REPORT UPDATE

Application No: H/1/11/

PLANNING APPLICATION REPORT

PROPOSAL: Re-erection of 2 barns and 2 sheds. (This application falls within the South Downs National Park Authority)

Elevations Existing

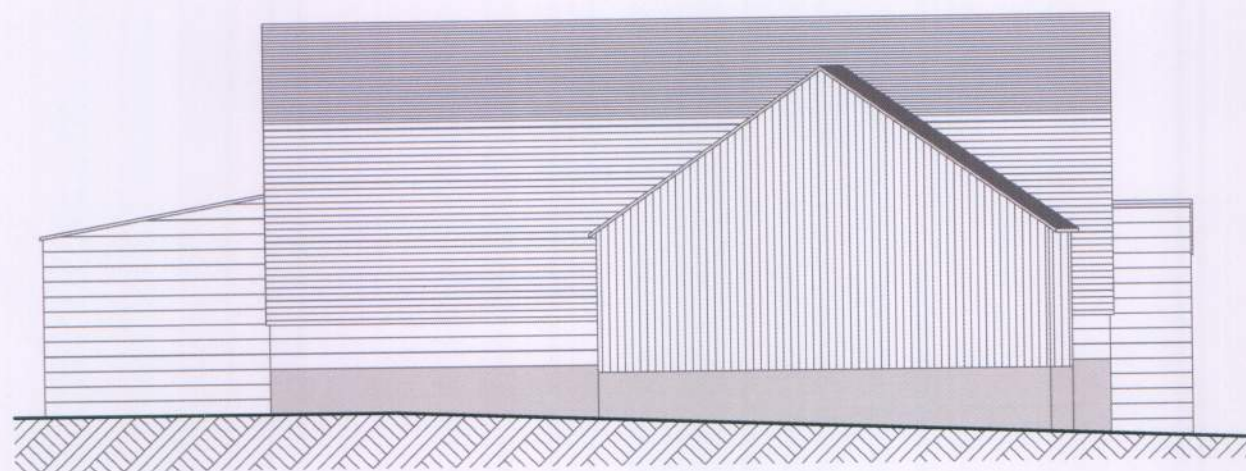
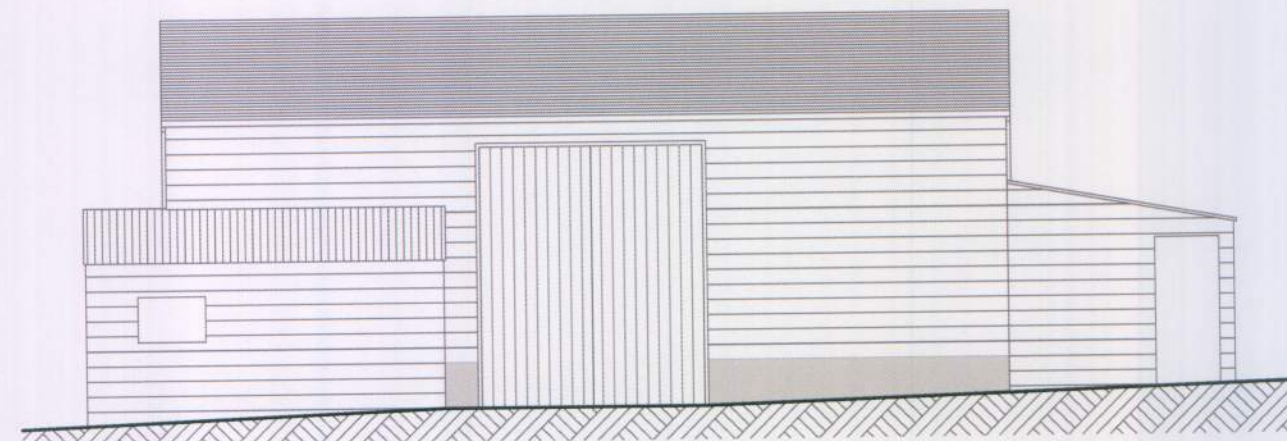
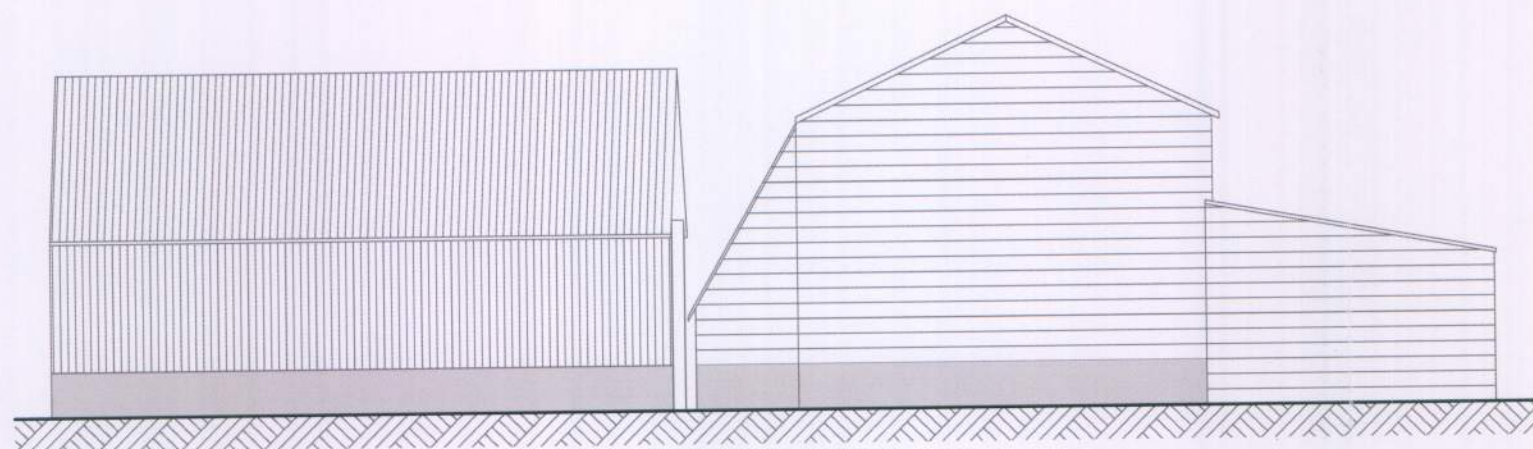
Concerns regarding overall height of roofline compared with original building by some 4-5 feet higher. The proposed roofline for the rear building also appears to be higher than the current one.

The footprint of the building will be altered and the height will be amended. The roof of the main barn will be increased by 1.5m in height.

Elevations Proposed

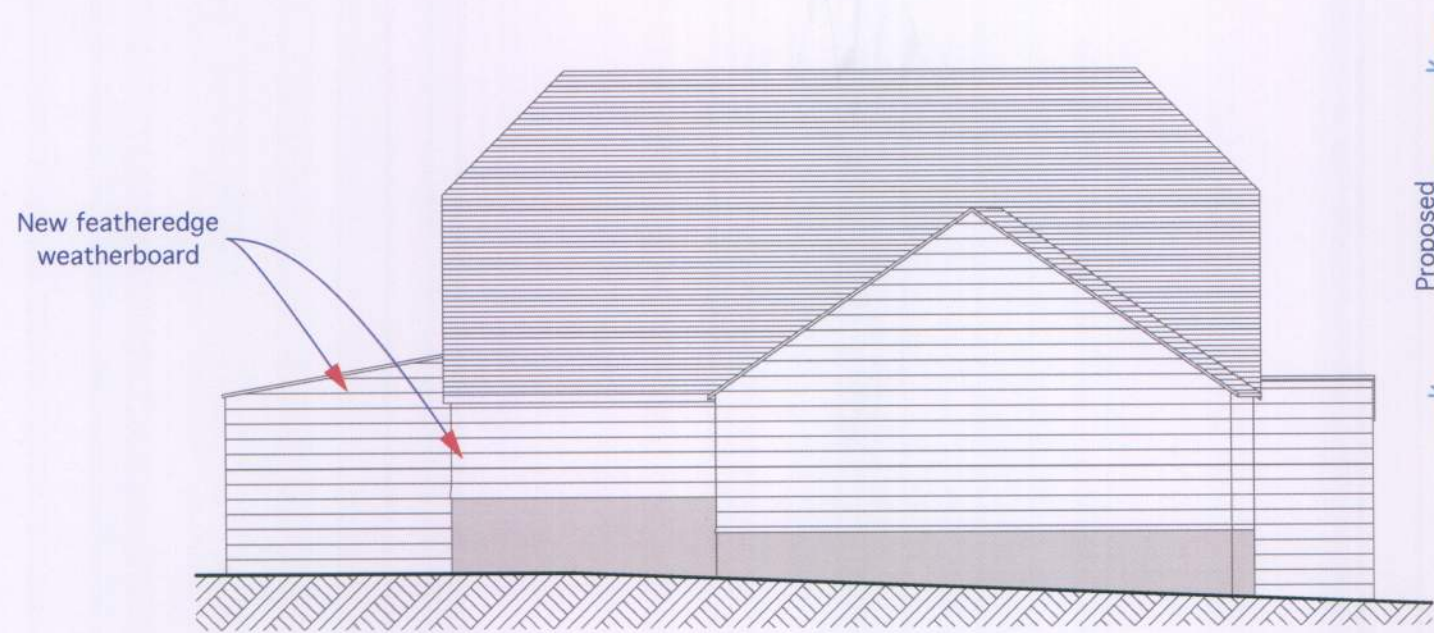
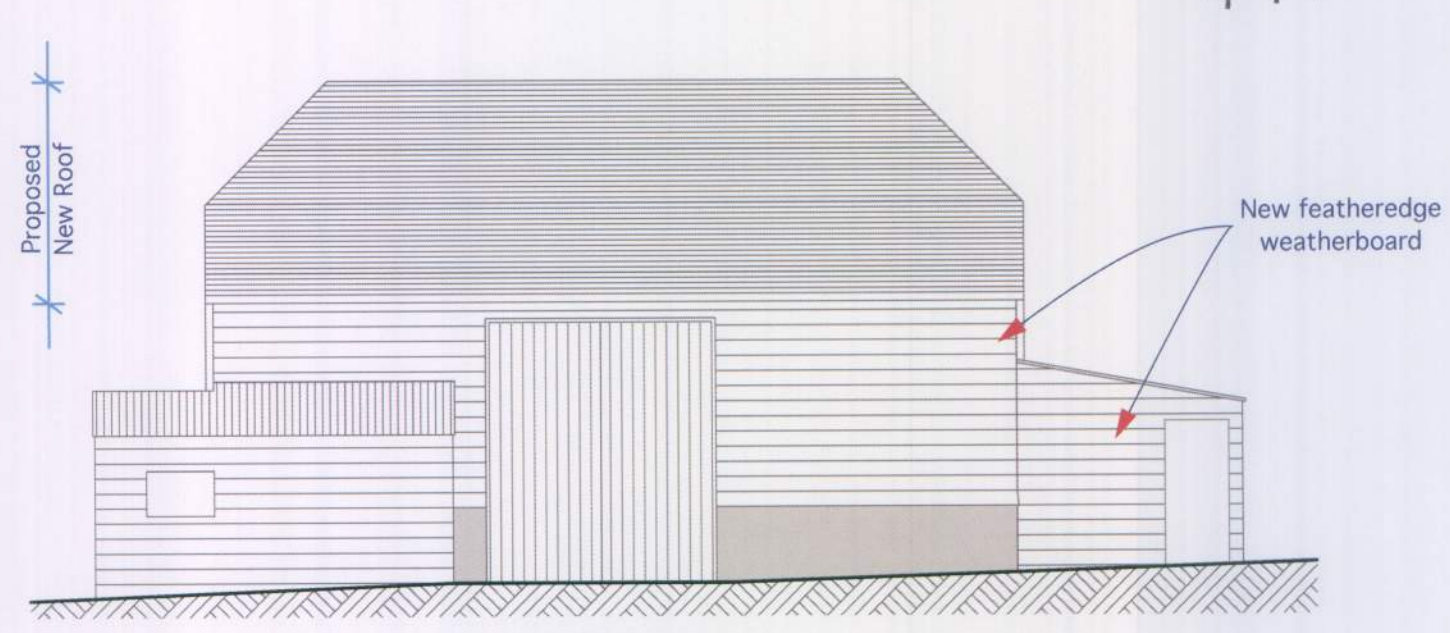
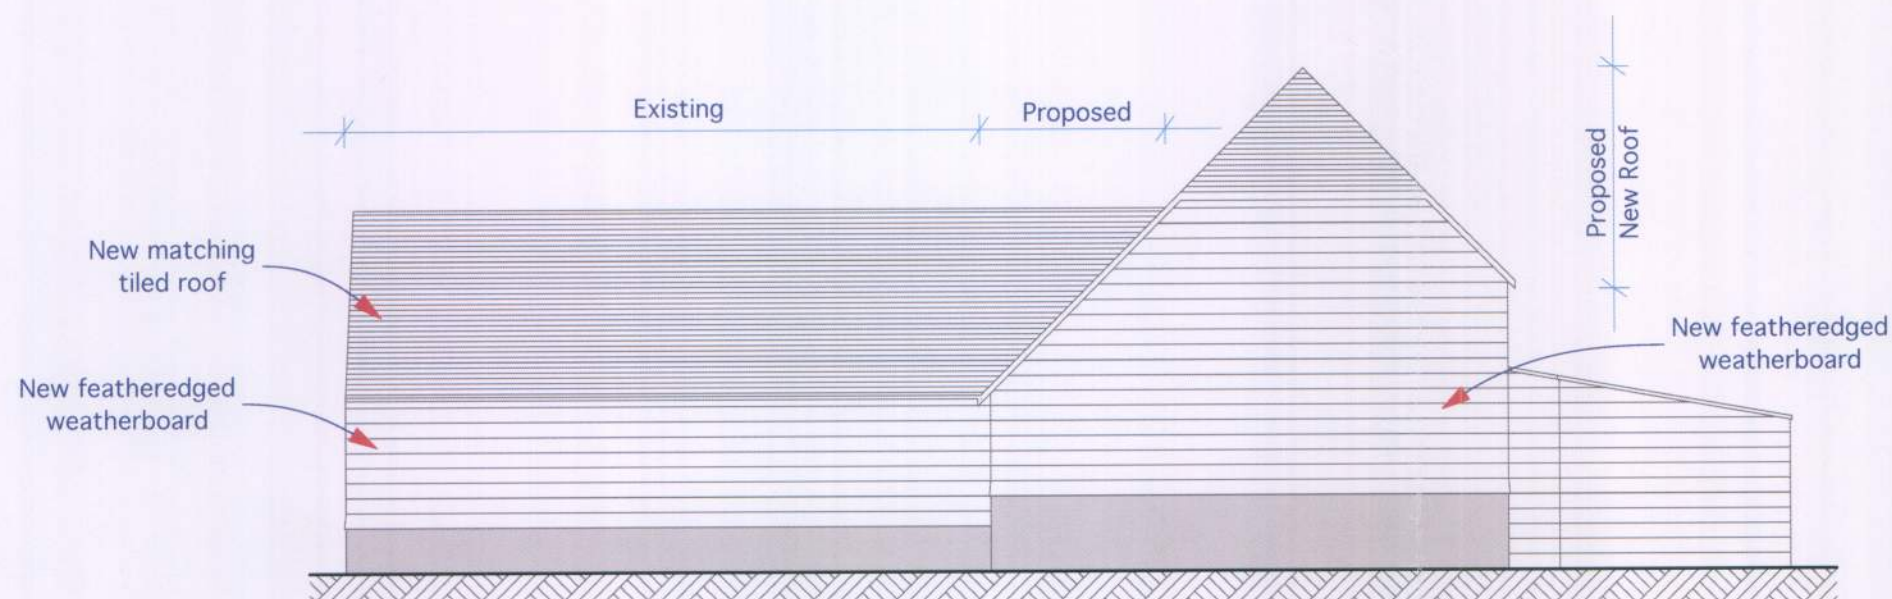
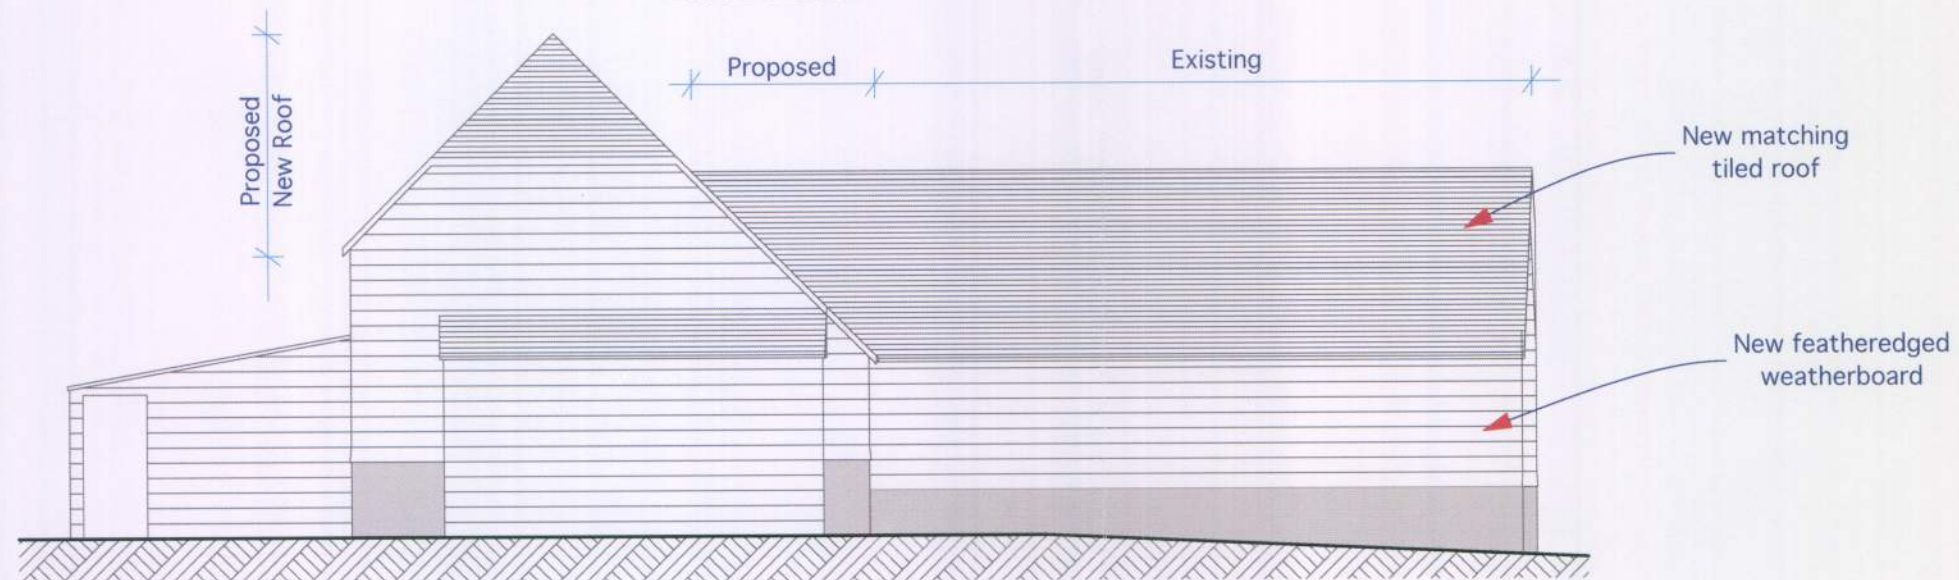
Roofline is higher than the original It is very intrusive. Concern raising height of semi-derelict corrugated iron shed to the south of the barn when rebuilding and ultimately apply for change of use of the whole to residential. Works have commenced without permission. Building is substantially larger and a serious eyesore located at the end of a lane leading to a major national trail in a newly designated national park. Devaluation of property. Loss of light.

No objection. Roof to be of hand-made clay tiles.

Devaluation of property is not a planning matter. The size and design of the building is in keeping with the proposed agricultural use. Given the distance of the building to site boundaries and adjoining residential properties and the 1.5m increase in height it is not considered any materially adverse loss of light would result to neighbouring properties. If an application is subsequently submitted for conversion to residential use it would be considered on its own merits in relation to policy at that time.

A condition is suggested controlling the roofing materials.
